Office of
Environment
& Heritage

Our Ref: DOC15/514183

Re: Major Project - Proposed Expansion of Sly's Quarry SSD 6624

Enclosure: Attachment 1: Detailed OEH Comments – Slys Quarry Biodiversity Assessment Report.

Subject site Hibbertia Marginata

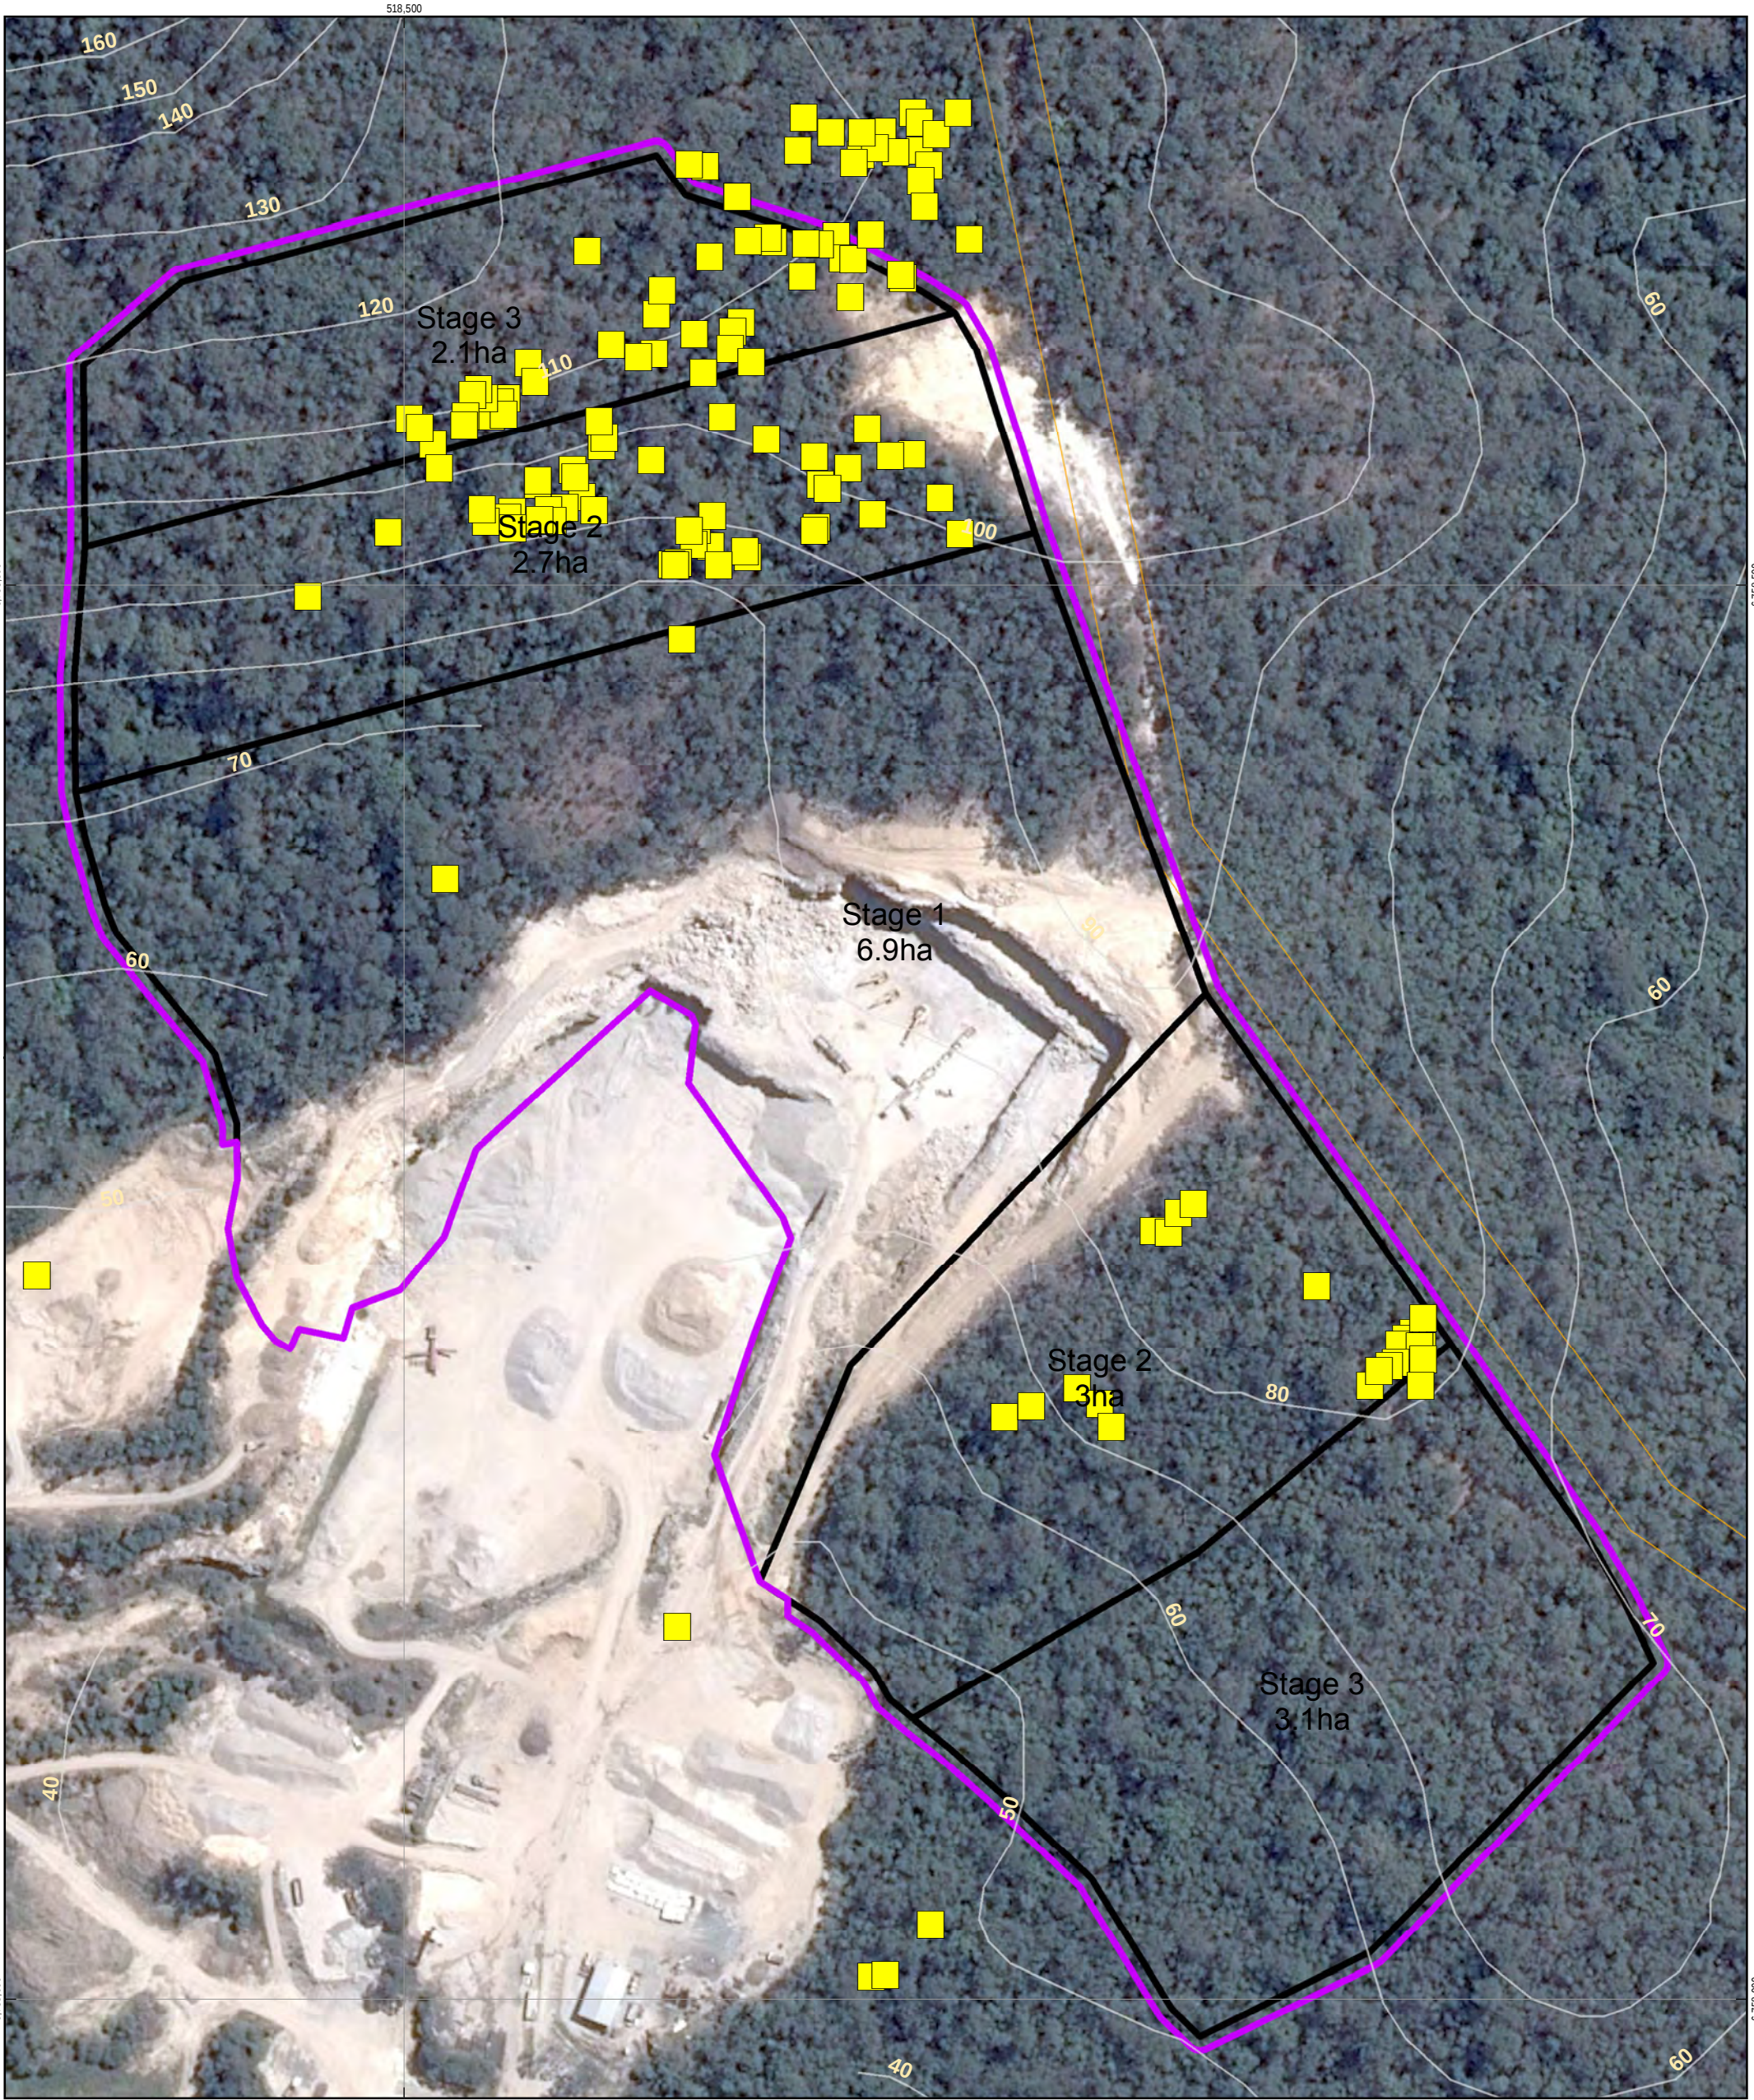
However, the BAR needs to be updated to provide information relating to the species polygon for the bordered guinea flower (*Hibbertia marginata*) which is known to occur on site, as required by section 6.5.1.14 of the FBA.

- j) The BAR needs to be updated to provide information relating to the species polygon for the bordered guinea flower (*Hibbertia marginata*) which is known to occur on site, as required by section 6.5.1.14 of the FBA.
